**Consultation Response from Emma Mills
 KC Landscape**

Application No:	2023/90348
Proposed Development:	Erection of community sports complex (within a Conservation Area)
Location:	Former Hillhouse Bowling Club, King Cliff Road, Birkby, Huddersfield, HD2 2RR
Applicant/Agent:	Acumen Designers & Architects Ltd
Planning Officer	Ellie Worth
Date Responded:	23.08.23
Responding Officer:	EM
Responding Ref:	MM36

SITE PLAN
 1 : 500

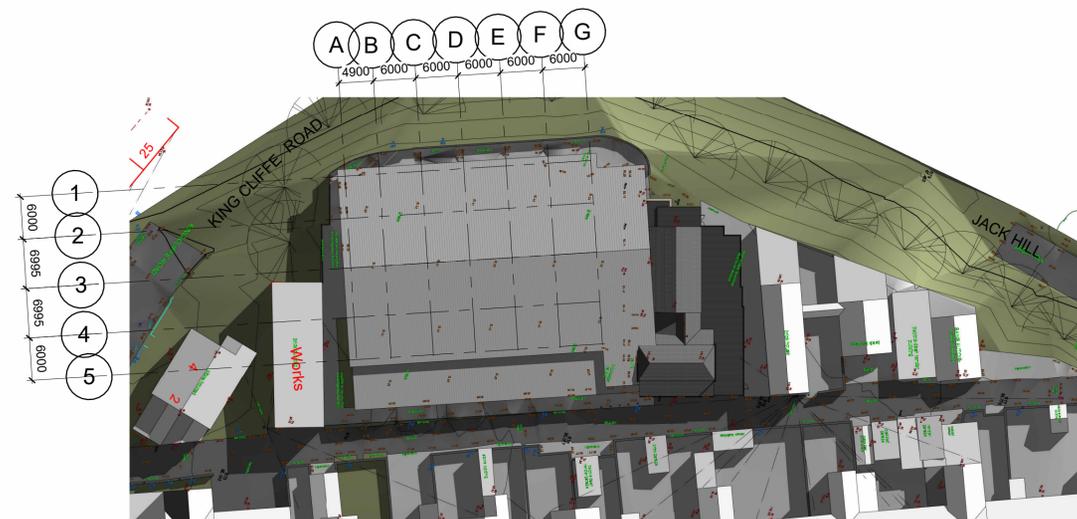
No Landscape proposals in this proposal but we would like to see the external hard surfacing proposals for the outside areas, particularly given its location in the conservation area. Choice and specification of materials is important.

Also, given its location in the conservation area, we will require information regarding proposals for protection of the existing trees beyond the boundary, particularly during construction as root protection zones will need protection with fencing and construction in such proximity will need addressing/no storage of materials/cutting back of overhanging branches etc.
